Submission in relation to State Significant Development Application Number SSD-82900461; 11-19 Middle Harbour Road, Lindfield

WEST ELEVATION
1:200

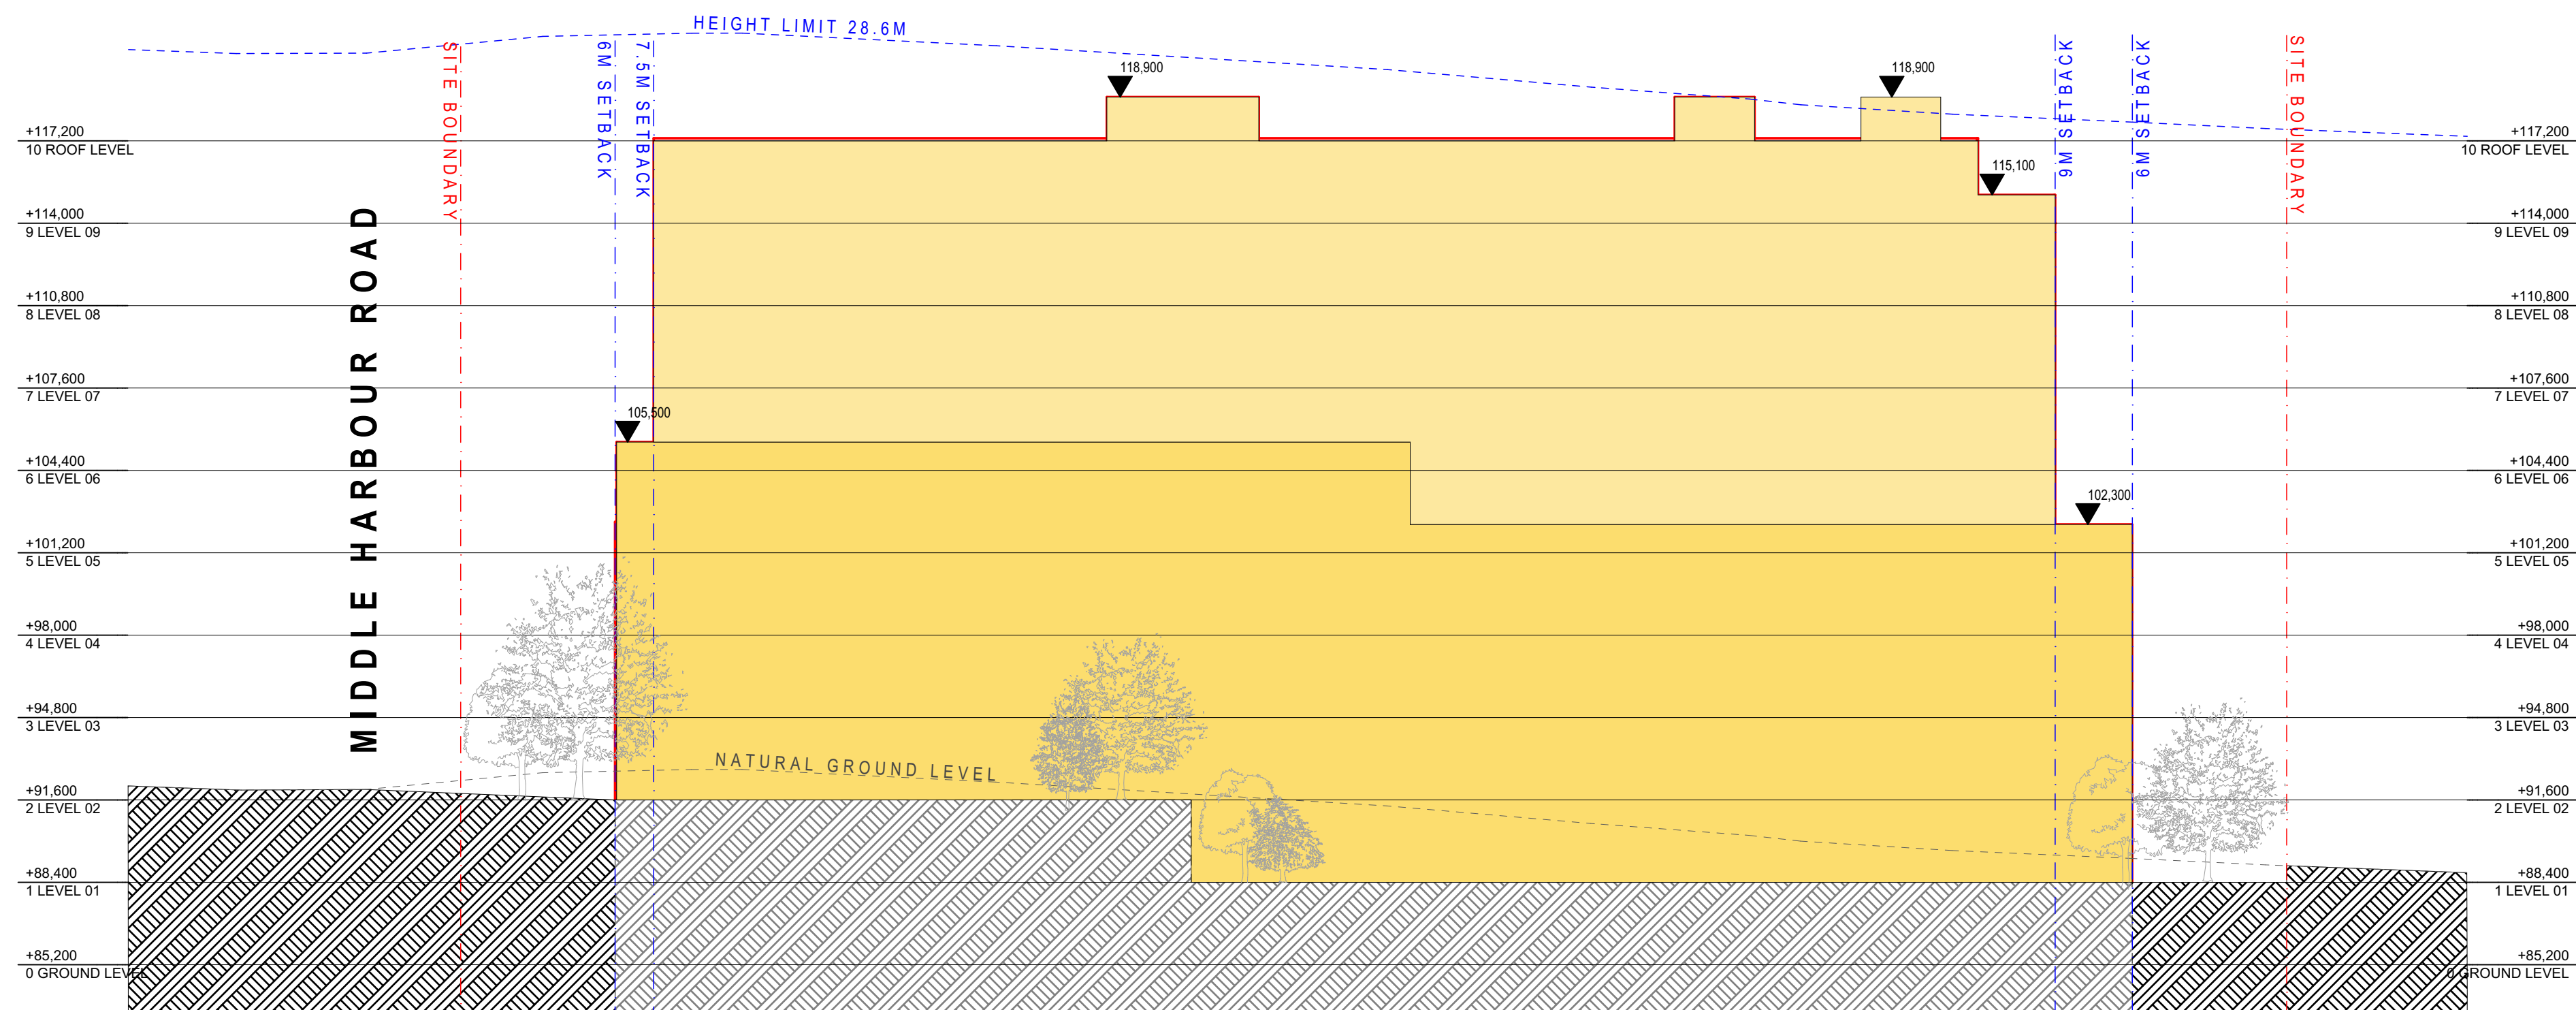
The eighth objection is to the loss of solar access and privacy for surrounding homes that the development will cause. A development in excess of 33 metres in height will have a detrimental affect on many neighbouring properties in terms of:

- (a) the overshadowing of houses to the east and west of the development site and the resultant loss of solar access, exacerbated for those properties to the east by reason of the elevated site location vis a vis the properties located to the east; and
- (b) the loss of privacy of the residences in the vicinity of the development, with floors 2 to 9 looking down on the surrounding properties, including their pools, backyards and outdoor entertaining areas.

## GROUND FLOOR LANDSCAPE PLAN

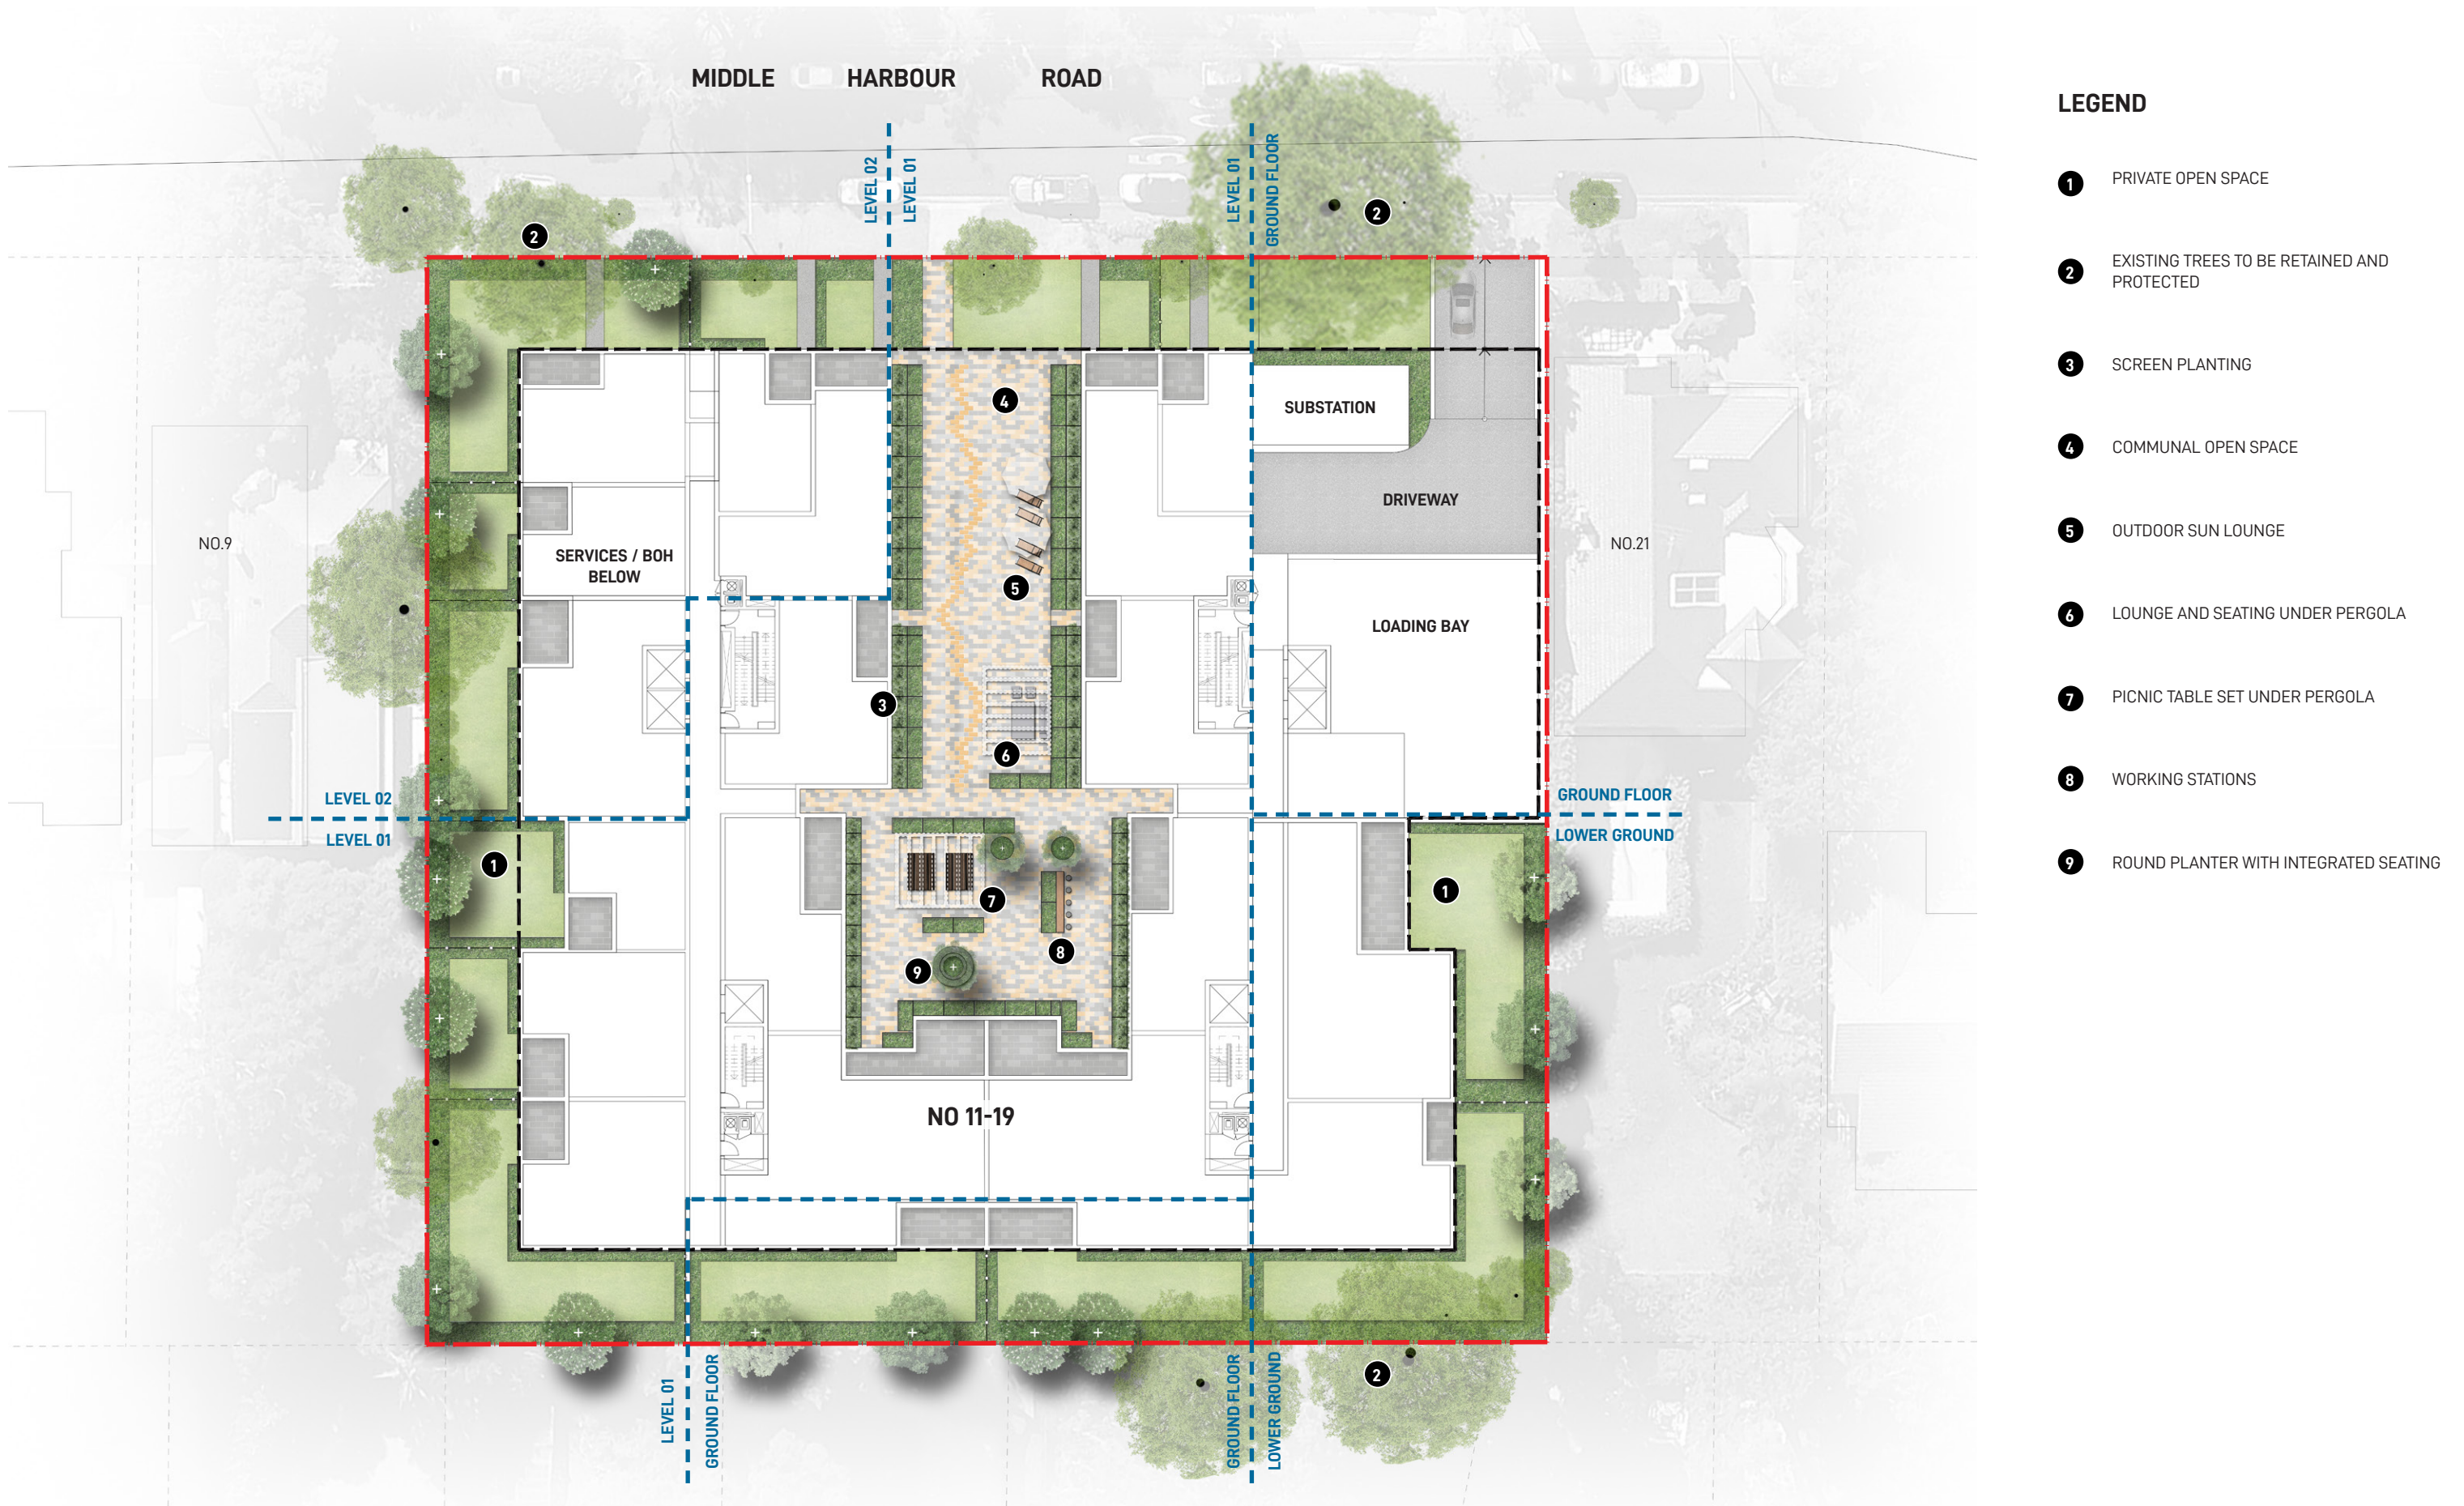
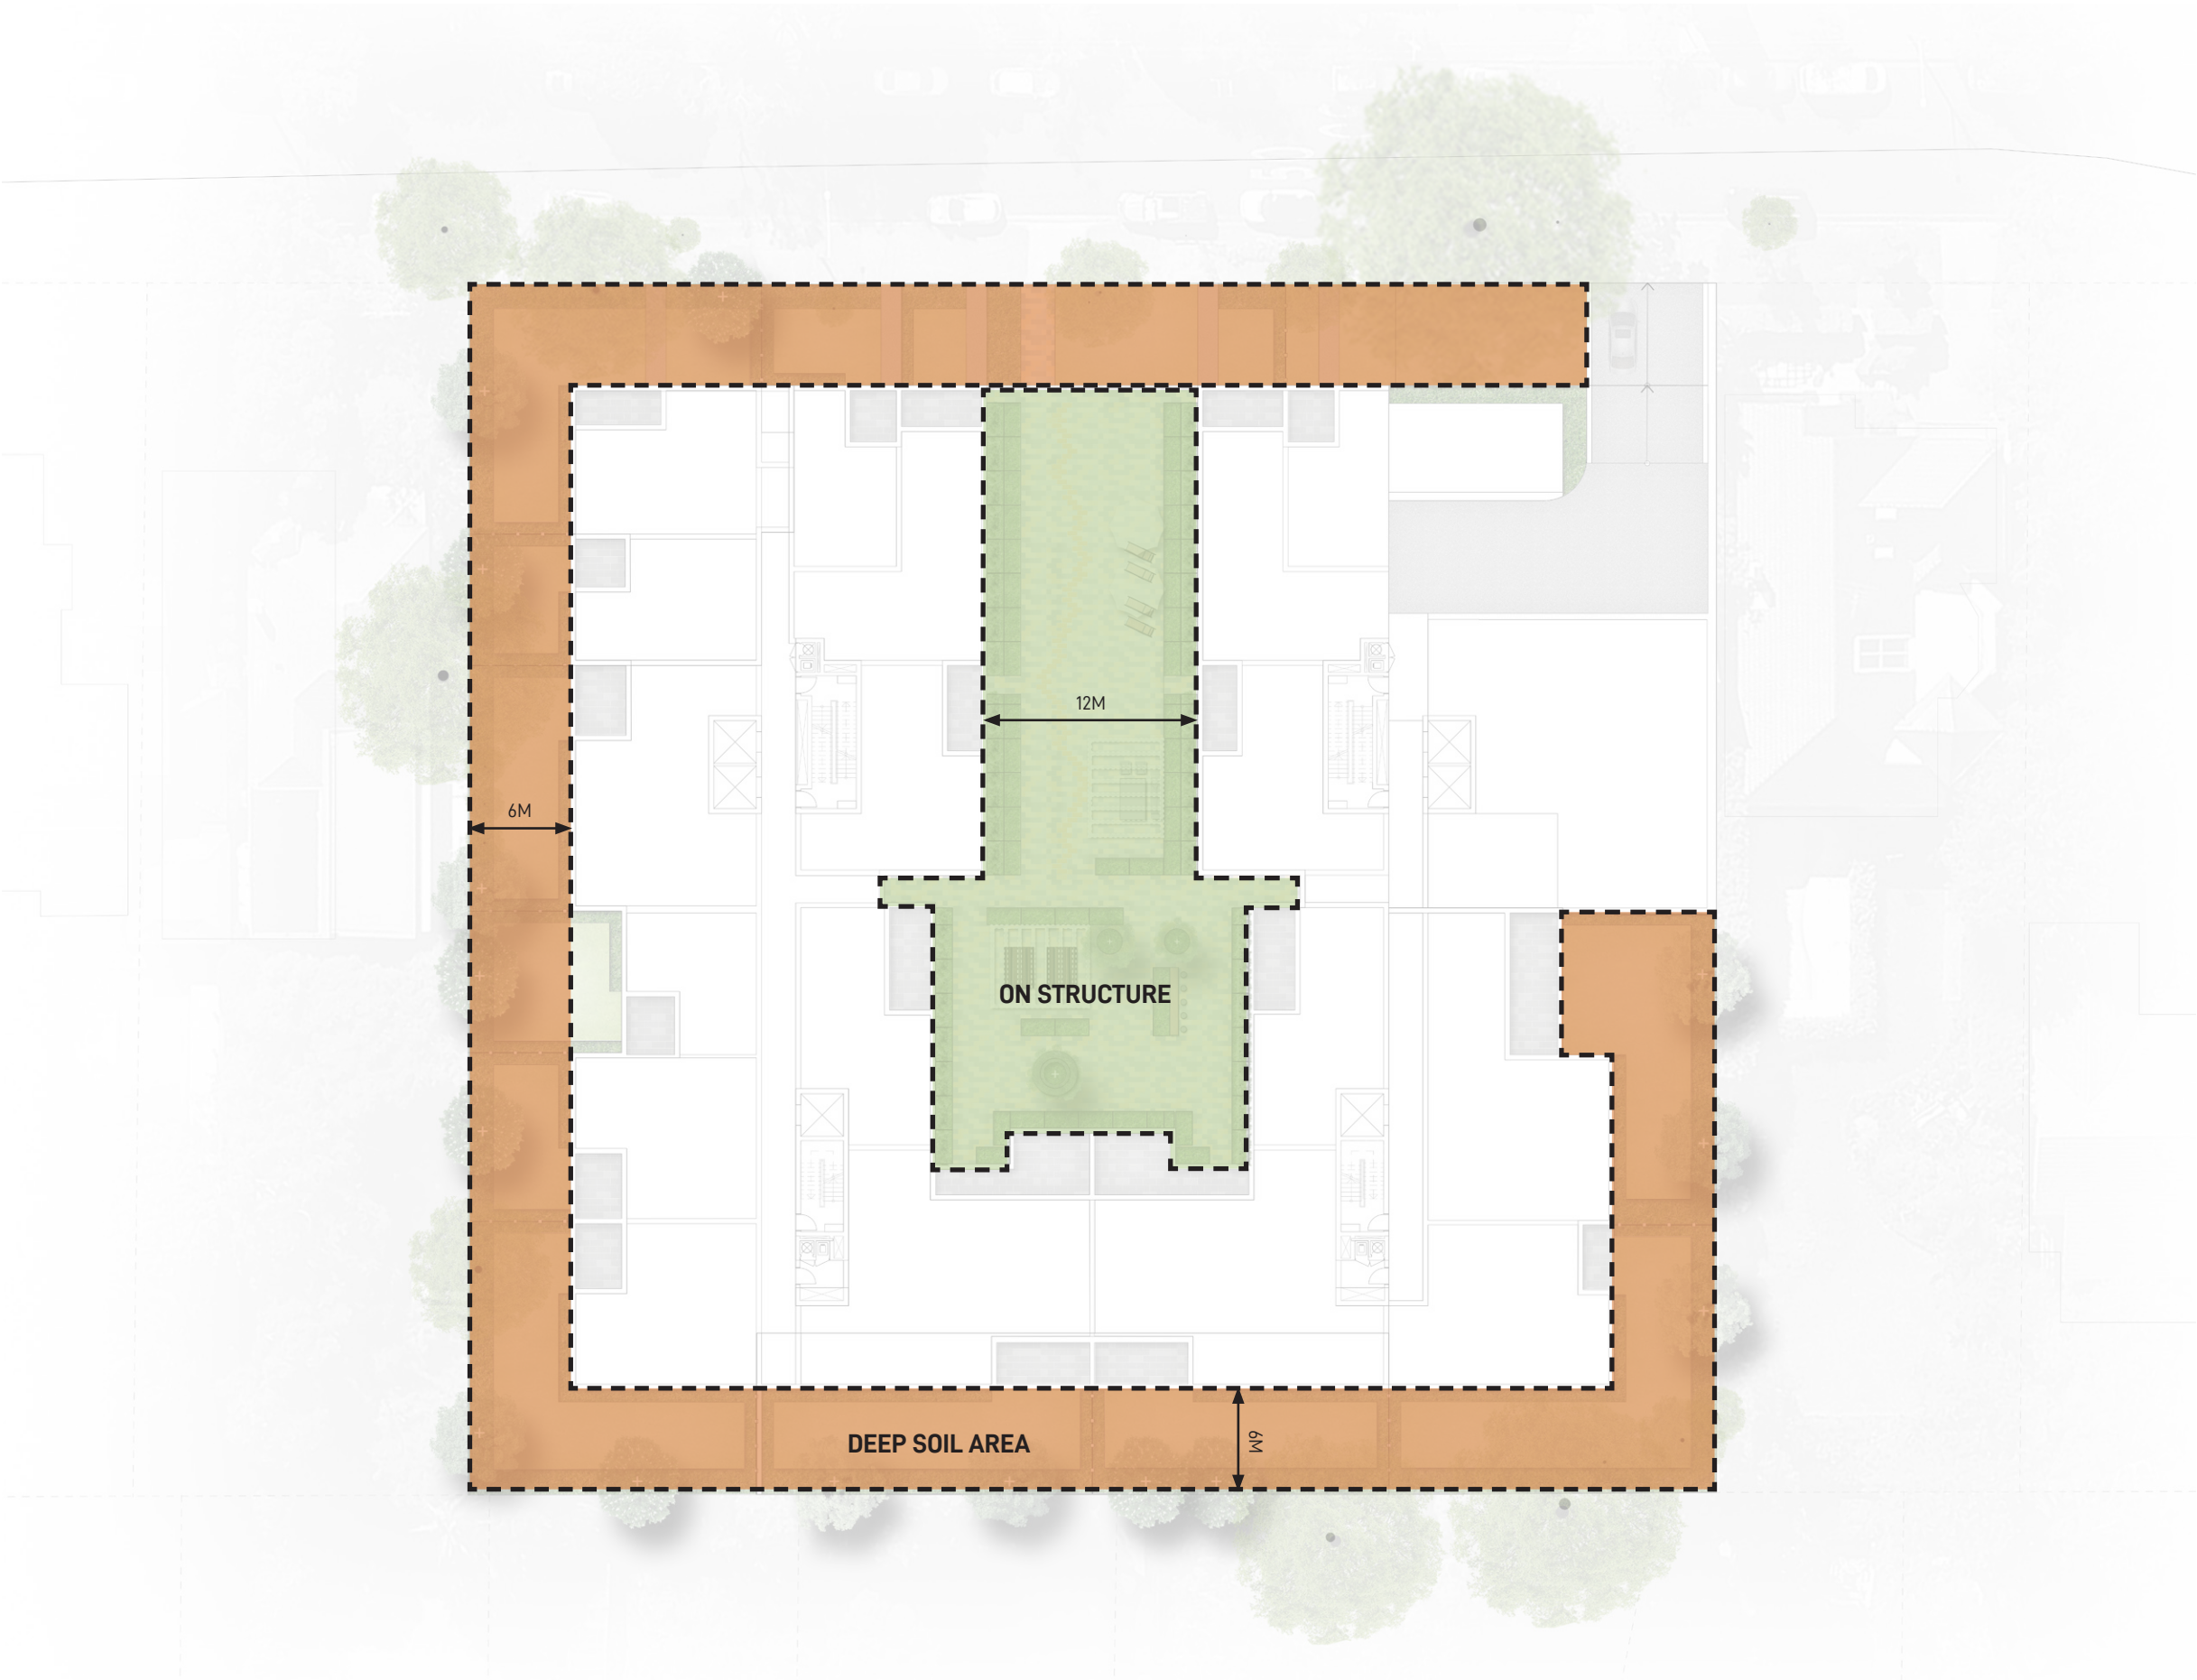
The fourth objection to the proposed development is that loss of the majority of the mature trees on the development site, of which there are many as can be seen from the aerial photos of the site. The Ku-ring-gai Council area represents a major part of the green lungs of the Sydney metropolitan area and the loss of a significant part of that green canopy is to the detriment of all Sydney residents. Further, given the bulk and size of the development with minimal setbacks, there will be little space for significant trees to be planted as part of the development to compensate for the loss of existing tree canopy and to soften the visual impact of the bulk and size of the development. This is a poor development outcome and will add to the heat sink affect to the immediate area.

37	<i>The Landscape Plan concentrates deep soil planting around the site boundaries. The landscaping will provide a balance between the natural and built features of the site and will assist in articulating the built form as viewed from the public domain.</i>	Note that this is not a statement that the deep soil planting is sufficient or appropriate.
62	<i>Importantly, the bulk and scale of the concept proposal, whilst notably greater than the existing scale of development with the locality, is in transition to higher density development envisaged by the Housing SEPP. Therefore, the concept envelope will be compatible with the desired future character of the locality while still having regard to the existing character of development. This is clearly shown in Figure 38 below which contains an extract from the Architectural Plans prepared by DKO Architecture and provided at Appendix 9. The 3D modelling shows how the proposal would sit within the context of the surrounding properties following redevelopment in accordance with the permissible building height and densities under Chapter 2 and 5 of the Housing SEPP.</i> And Figure 38 showing similar 9 storey development surrounding the proposed development.	Ignores any likelihood that the Kuring-gai Preferred Alternative Planning Scheme (which is highly likely to be approved by the State Government as it meets the required housing targets) will be approved and that the immediately surrounding development on the southern side of Middle Harbour Road will be limited to five storey residential buildings and 18.5 metres height
